Our Ref: 23/11033

Proposal: Replacement of windows with wooden conservation windows (Application for listed building consent)

Site: WILLOW COTTAGE, HIGH STREET, DAMERHAM SP6 3EU

VERTICAL SECTION DETAIL
- GLAZING BAR DETAILS

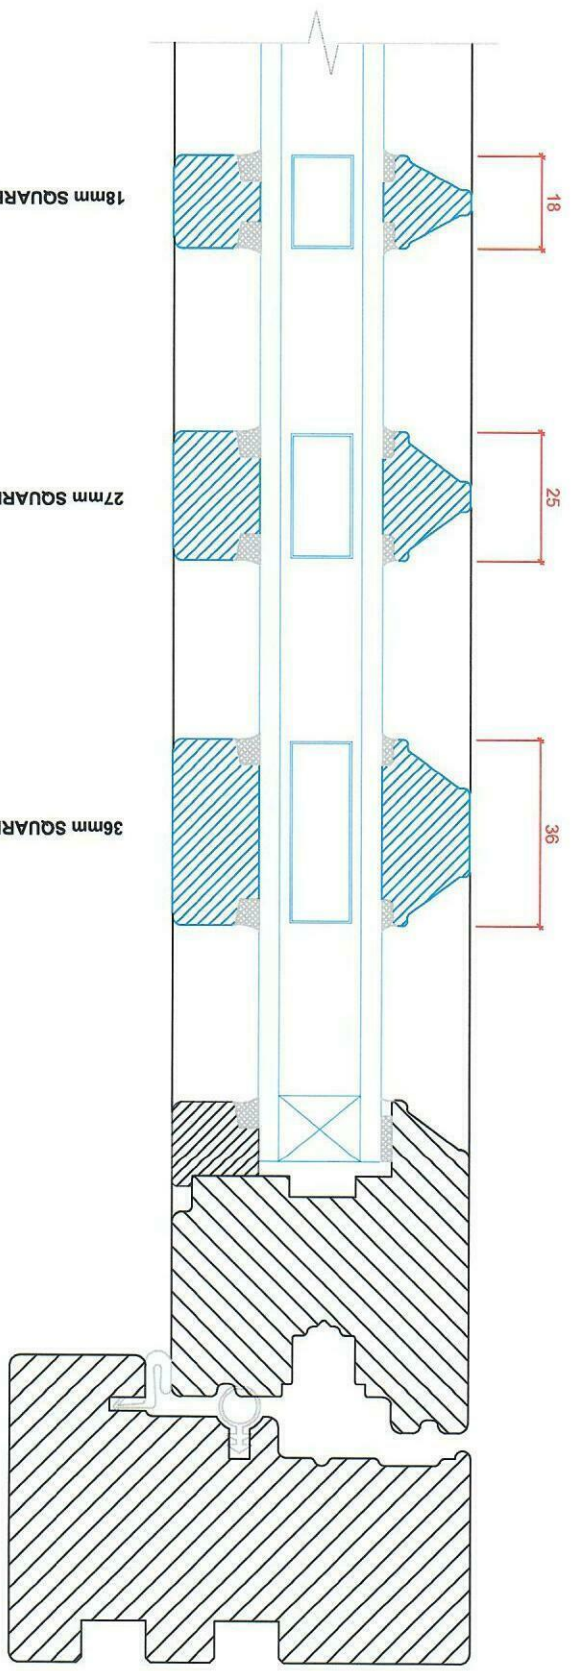
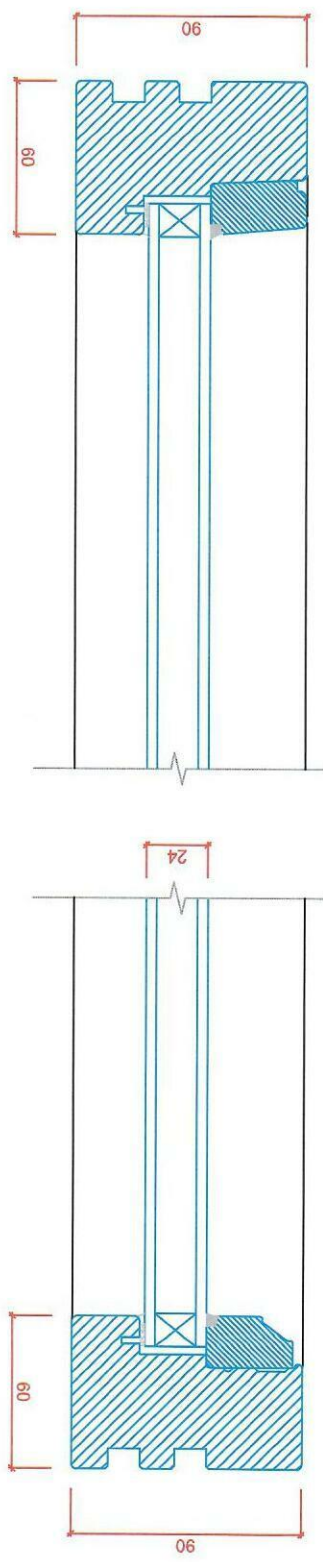
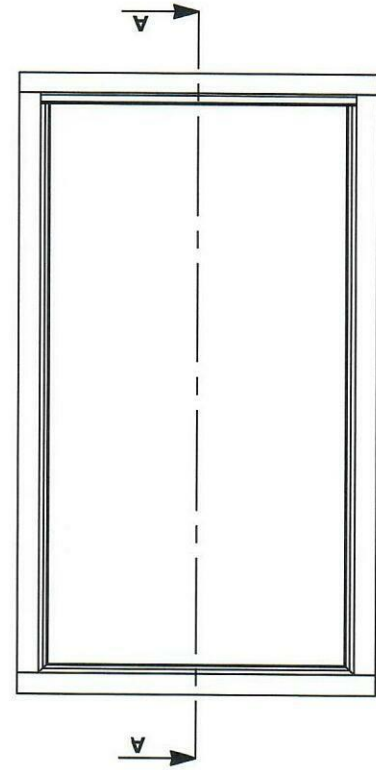
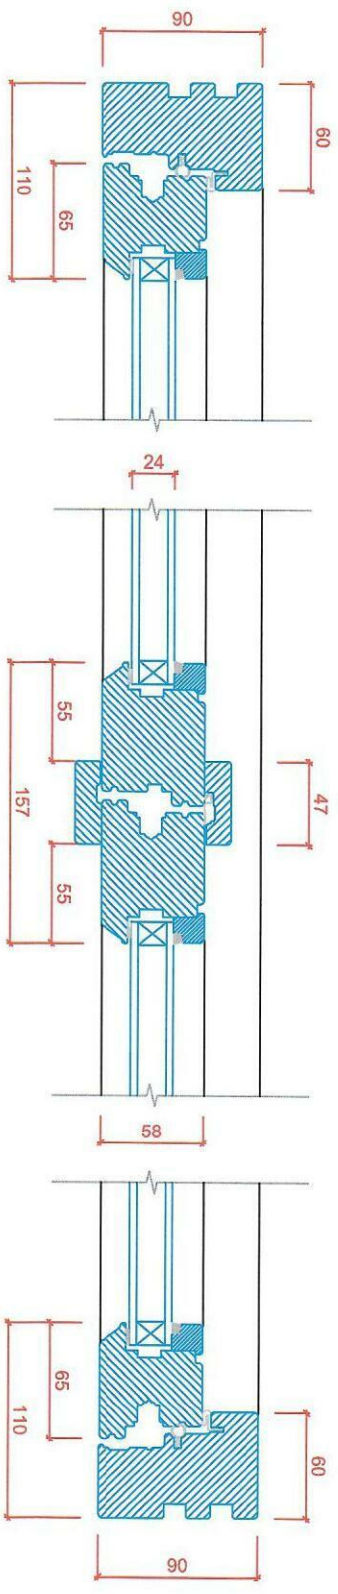
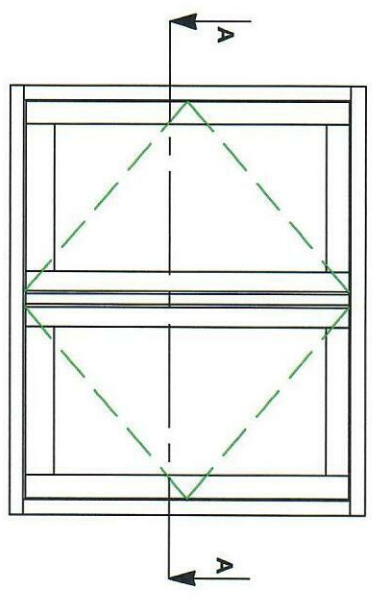
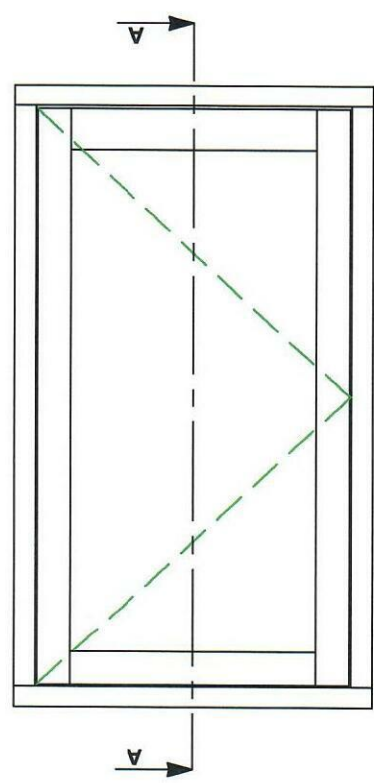
We note that the proposed replacement windows would be double glazed and the mullion bars would not be integral. This raises concerns and would not normally be acceptable, so you may want to reconsider this detail at this stage.

Drawing
Existing Elevations
+ Proposed.

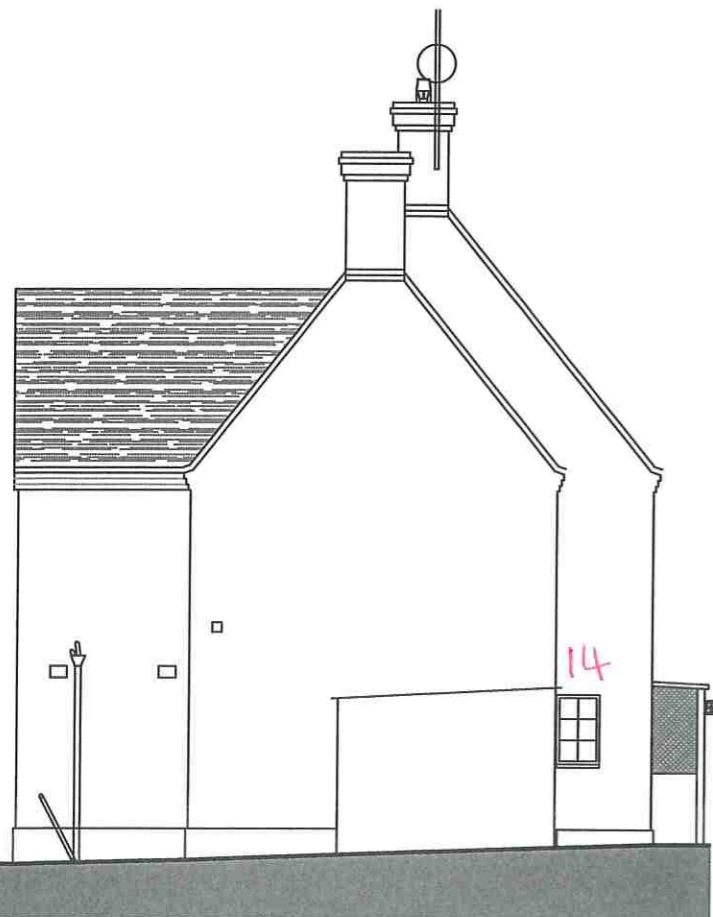
The conservation officer requires further information to be submitted to allow a proper assessment of the proposal as there is no window schedule or sufficiently detailed assessment of the existing windows that are proposed to be replaced in order to justify the proposed works accompanying the application. Their comments are available to view on line, but to summarise, the additional information required is as follows:

- detailed photographic schedule of the existing windows to be replaced, to show the following:
 - character of each window to which works are proposed and assess the windows contribution to the significance of the asset
 - Where frames are to be replaced, evidence that the historic fabric is either beyond reasonable repair, or its replacement is not consequential to the significance of the listed building.
